DELEGATED DECISION TO DETERMINE PLANNING APPLICATIONS

Reference No:	2023/62/91322/E
Site Address:	14, Linton Avenue, Healey, Batley, WF17 7HP
Description:	Erection of first floor extension and external alterations
Recommending Officer:	Nicole Helliwell

DECISION - REFUSED

Officer Report

SIDE ELEVATION

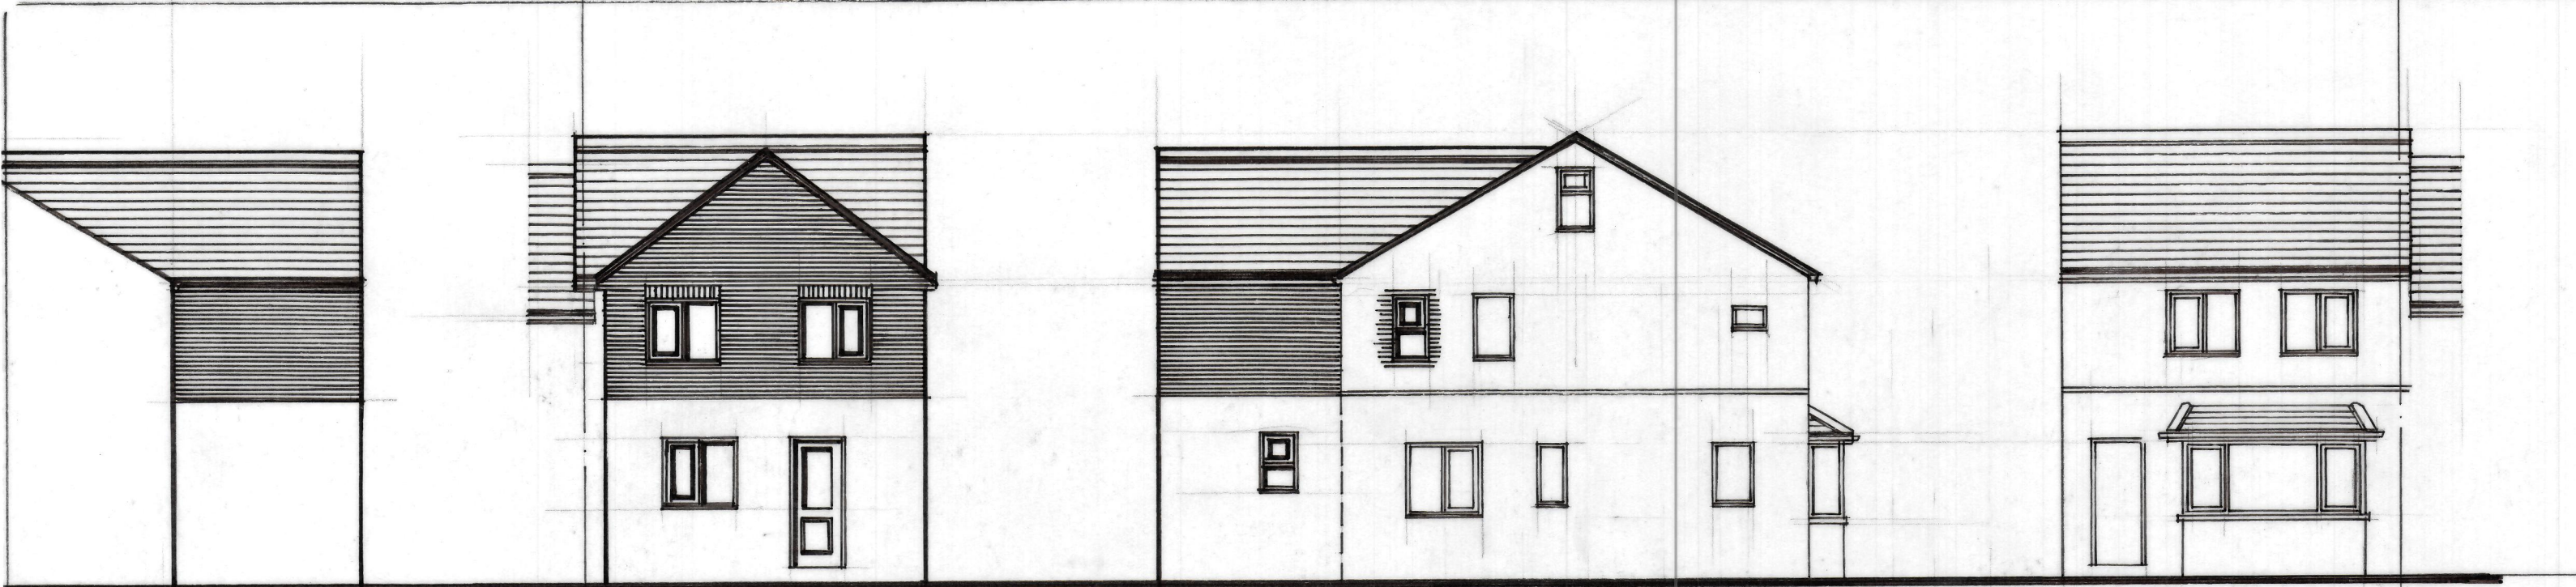
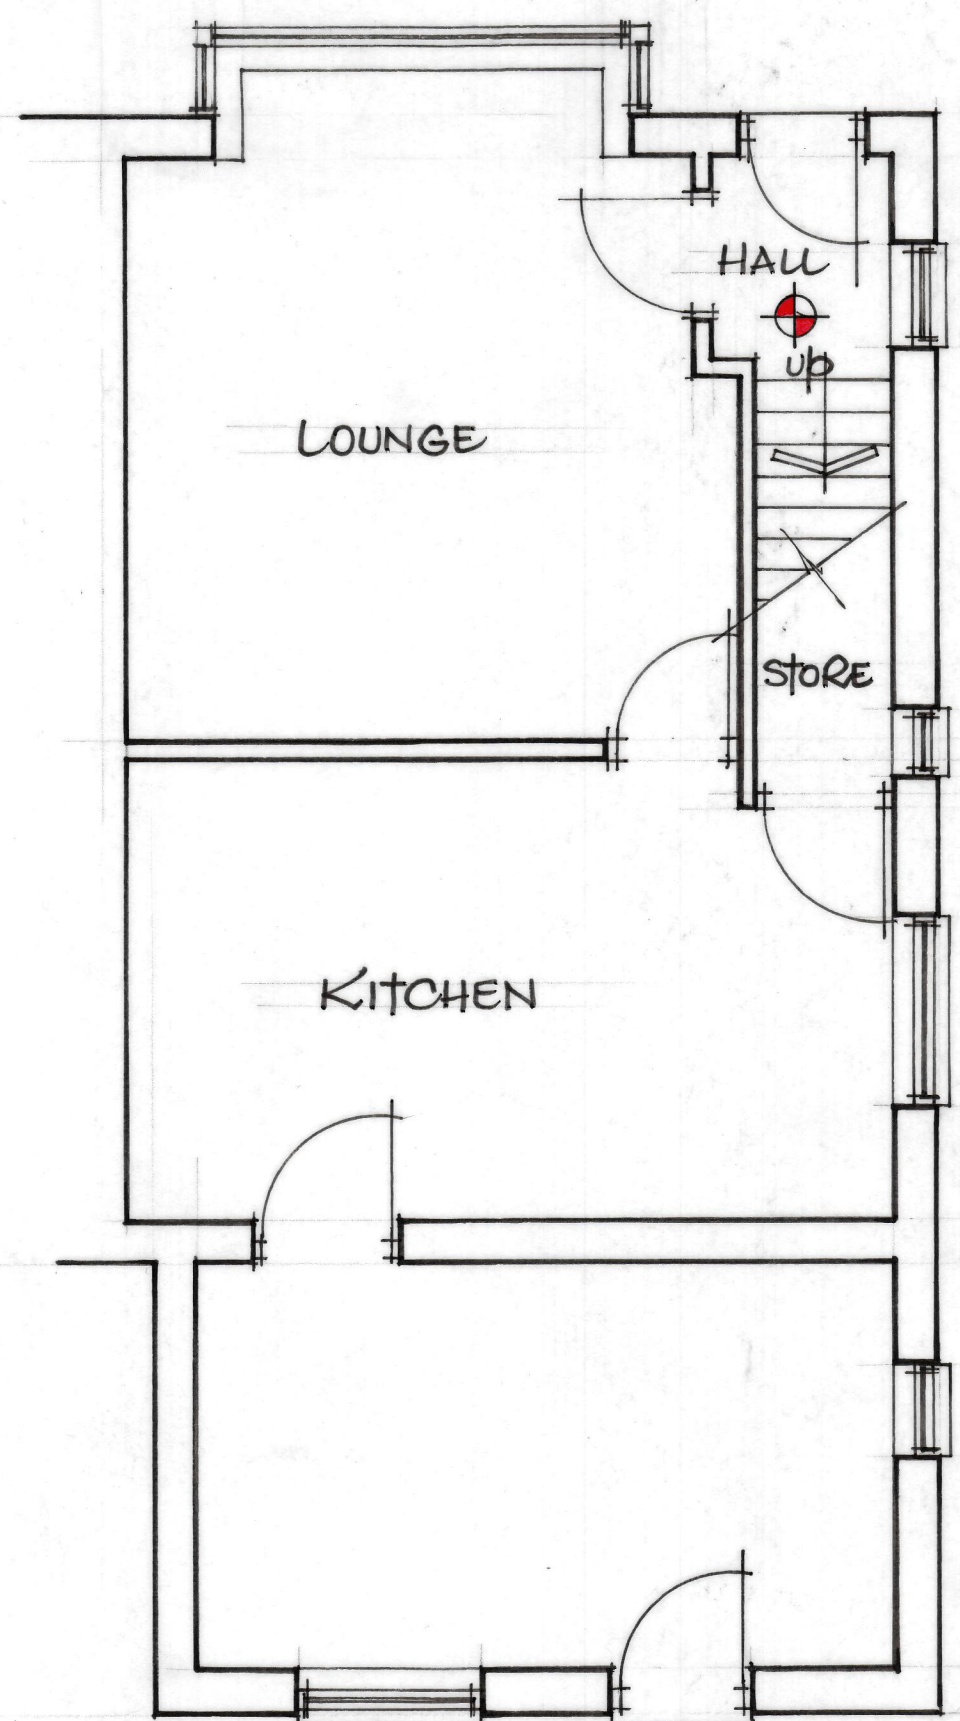
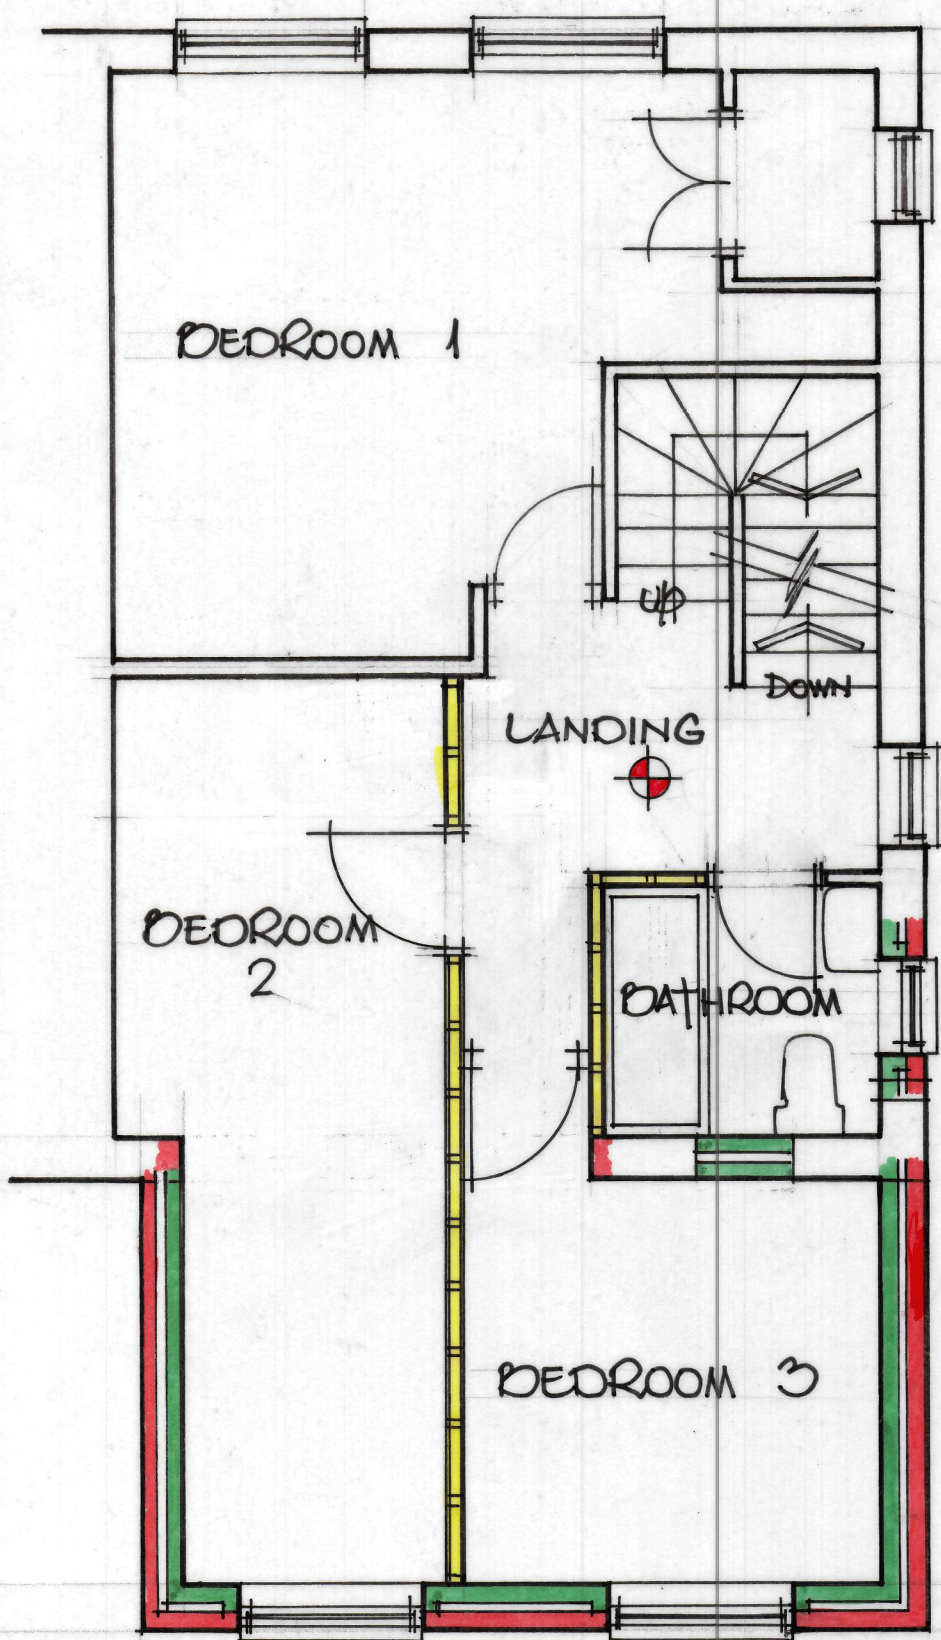
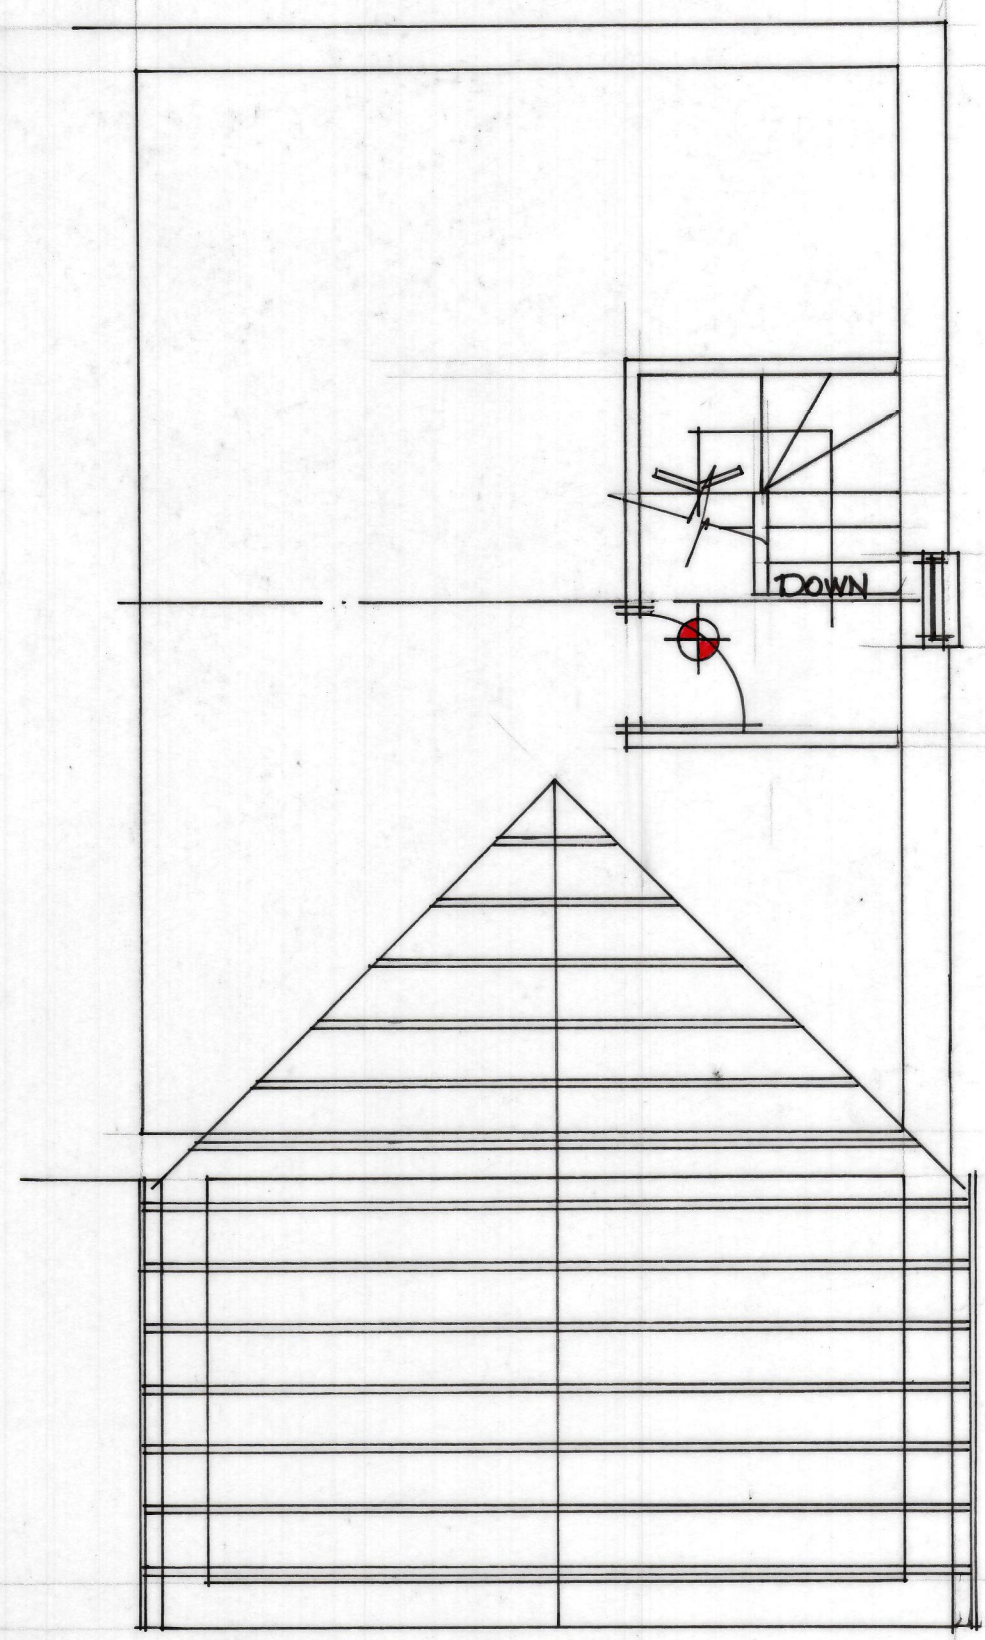
The proposed first floor rear extension would be positioned approximately 0.3m from the common boundary shared with 16 Linton Avenue and would fail to accord with the 45-degree rule in relation to the neighbour's first floor windows. Therefore, it is considered that the proposal would result in an oppressive and overbearing form of development due to its scale, design and proximity. As such, the harm caused to this neighbour would be detrimental and cannot be supported in terms of residential amenity.

Having considered the above factors, the development proposed would have an oppressive and overbearing impact upon the residential amenity of the neighbouring occupants at 16 Linton Avenue, thereby failing to comply with Policy LP24 of the Kirklees Local Plan (b) in terms of the amenities of neighbouring properties, KDP 5 & 6 of the House Extensions and Alterations SPD and Paragraph 130 (f) of the National Planning Policy Framework.

The proposed first floor rear extension, by reason of its scale, design and location would have an unacceptable overbearing and oppressive impact to the occupiers of no.16 Linton Avenue. To permit the development would be contrary to Policy LP24 of the Kirklees Local Plan, Key Design Principle 5 & 6 of the House Extensions and Alterations SPD and Chapter 12 of the National Planning Policy Framework.

1. Due to its scale, design and location, the proposed first floor rear extension would have an unacceptable overbearing and oppressive impact to the occupiers of no.16 Linton Avenue. To permit the development would be contrary to Policy LP24 of the Kirklees Local Plan, Key Design Principle 5 & 6 of the House Extensions and Alterations SPD and Chapter 12 of the National Planning Policy Framework.
